DATE: 24 April 2015

RE: **Groundwater Peer Review – Drayton South Coal Project**

OUR REF: HC2015/16

This report provides a peer review of the groundwater assessment undertaken for open cut mining for the Drayton South Coal Project (the Project). The groundwater assessment has been done by Australasian Groundwater and Environmental (AGE) Consultants Pty Ltd for Anglo American Coal (Anglo American). The Project is located about 10 km north-west of Jerrys Plains in the Upper Hunter Valley (NSW).

**Figure 7 Section showing folding within coal measures**

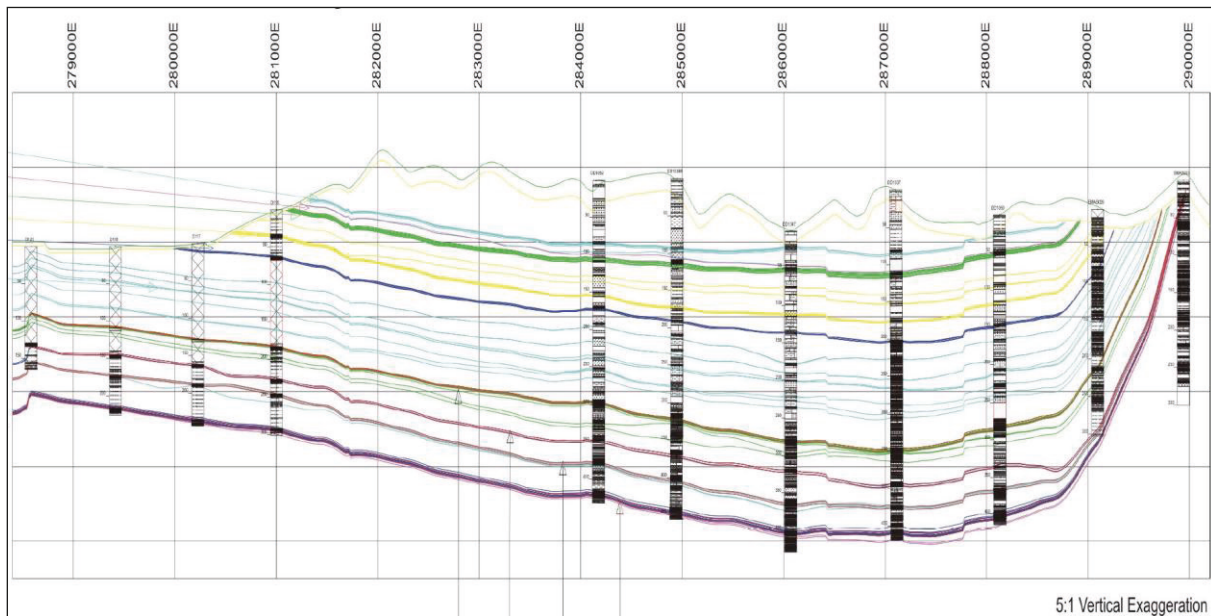
1. Figure 7 (detailed stratigraphy) should be given a vertical elevation scale.
2. Page 94, Paragraph 4 is ambiguous. It is not clear whether 555 mg/L is the average salinity or 1% of the average salinity.
3. In Appendix E, the water levels for VWP nests should be illustrated on the one graph to show comparison of actual and simulated hydraulic gradients.

**Figure 12 Hydrographs for VWP1 (RD1221)**

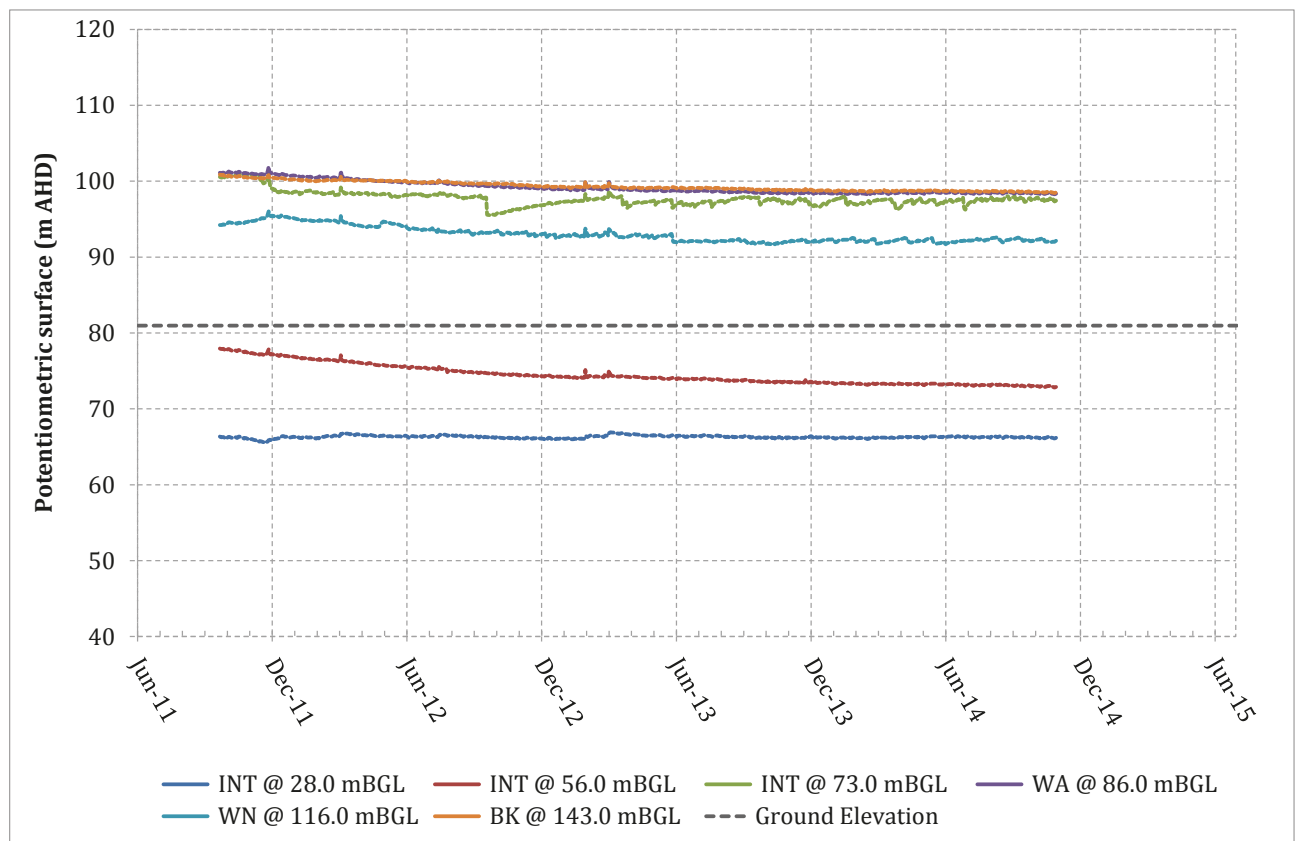
However, apart from one example of vibrating wire piezometer (VWP) responses [Figure 12], showing an upwards vertical gradient, there is no cause-and-effect analysis of the groundwater hydrographs [in Appendix B] to inform conceptualisation. Comment should have been offered on the hydrographs at bore RBD1 which appears to show a mining response in the Blakefield Seam but not in the Whynot Seam.

1. No cause-and-effect analysis of groundwater hydrographs other than for bore RD1221 [Figure 12].
2. Groundwater hydrographs are given in Appendix B, but mostly at uninformative scales.

5. Water level monitoring since 1998. Useful information on vertical hydraulic gradients is apparent but not emphasised, other than one example in Figure 12.

**Figure 14 Schematic section showing conceptual hydrogeology - during mining**

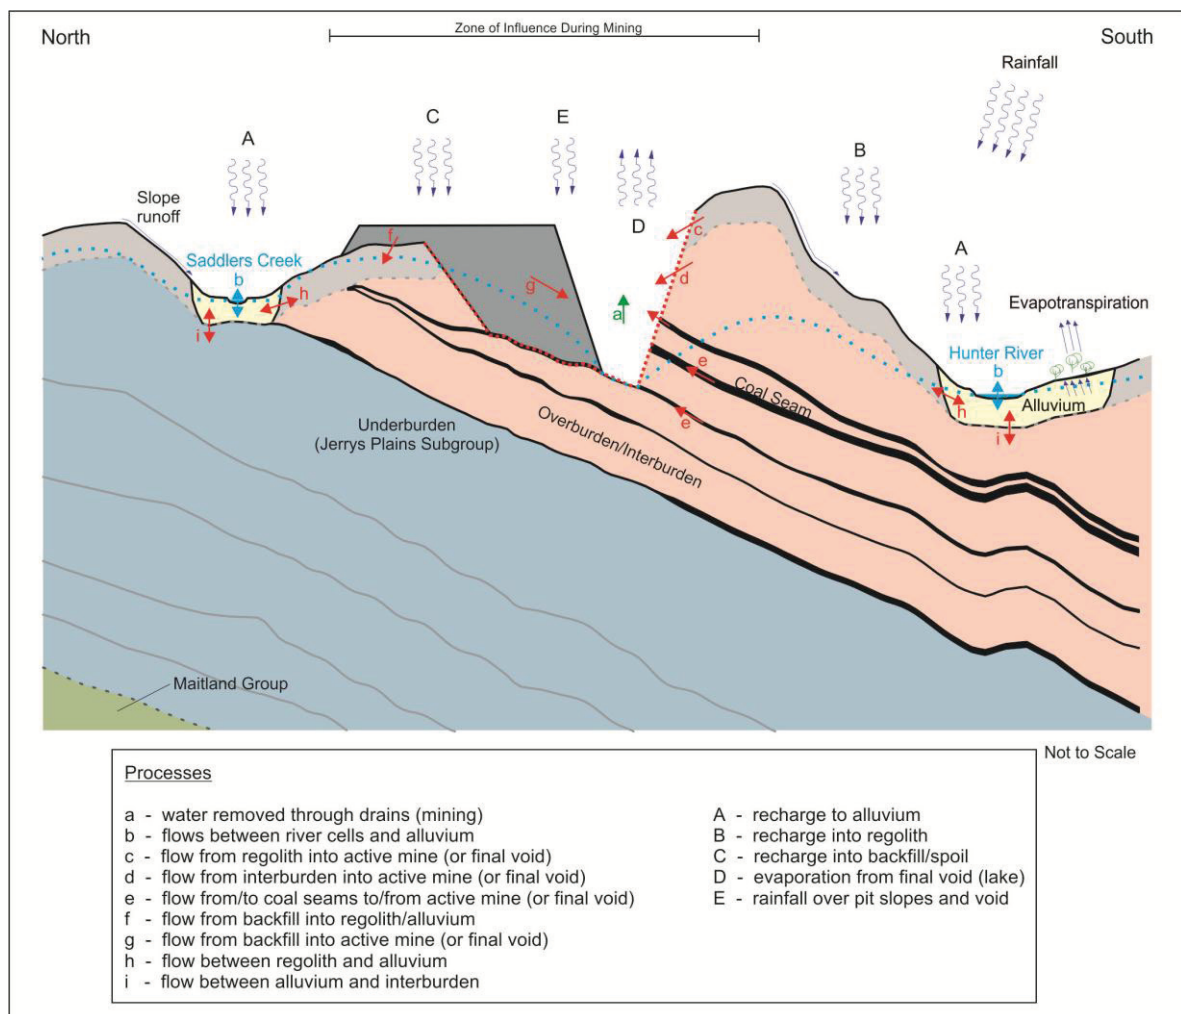
1. Comprehensive Executive Summary.
2. Good summary of the Aquifer Interference Policy and minimal harm considerations.
3. Good report structure and high quality graphics.
4. Project objectives are articulated clearly.
5. Although evapotranspiration (ET) is included in the conceptual model [Figure 14], it is not a component of the numerical model. This process would normally be included in the numerical model if there is evidence of depth to water being within a few metres of ground surface anywhere close to the planned mining operations. The reviewer is of the opinion that it is not sufficient to subtract this component from the incident rainfall in adopting a figure for net rainfall recharge.
6. "mAHD" should be used instead of "mRL" [Figure 16; Figure C3; all figures in Appendix E].

1. Valid and sufficient.
2. Excellent conceptual model graphic [Figure 14 and Figure C11].
3. The conceptual model graphic Includes ET but there is no ET quantification in the model as it is said to be "simulated by assigning a slightly reduced rate of recharge" [Section C1.2.5.3]. Specific inclusion of ET as a process could allow reductions of ET to be interpreted as impacts on GDEs.
